From: [REDACTED]
Sent: 02 June 2026 13:43
To: Planning
Cc: [REDACTED]
Subject: Formal Concerns Regarding Flood Risk, Drainage Infrastructure and Boundary Retaining Structure – Planning Ref: 3/2024/1022, 3/2026/0222, 3/2025/0971

PROPOSED DRAINAGE PLAN

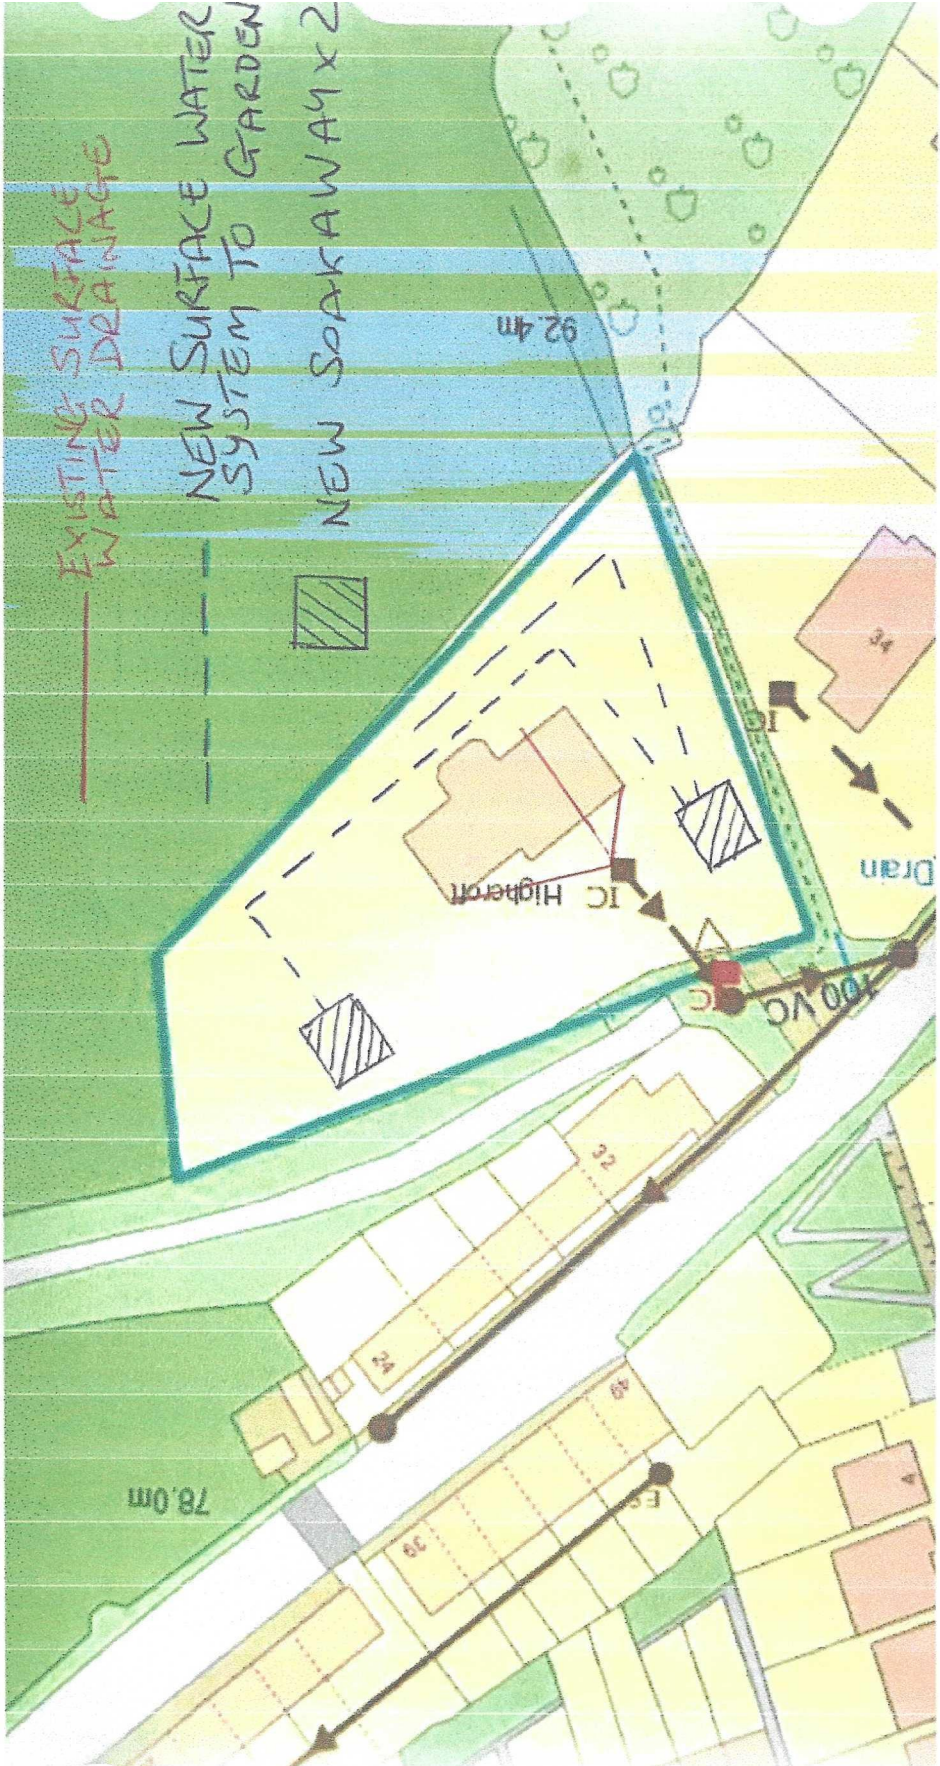
We are especially concerned that the drainage strategy appears to rely heavily upon soakaway systems which, by their nature, require ongoing inspection, maintenance, and eventual replacement. As soakaways do not have an indefinite operational lifespan and may become less effective due to silting, clogging, changing ground conditions, or inadequate maintenance over time, we would be grateful if the Council could clarify the following:

- What assurances can be provided that neighbouring properties will remain protected from increased surface water runoff throughout the lifetime of the development?
- What is the anticipated design life of the proposed soakaway systems?

- What inspection and maintenance regime will be in place to ensure their continued effectiveness?
- Who will hold long-term responsibility for maintaining the soakaways and associated drainage infrastructure?
- What contingency measures are in place should the soakaways fail, become blocked, or otherwise cease to operate effectively in future years?
- How has the Local Planning Authority satisfied itself that neighbouring properties will not be exposed to increased flood risk in circumstances where drainage infrastructure deteriorates or fails over time?
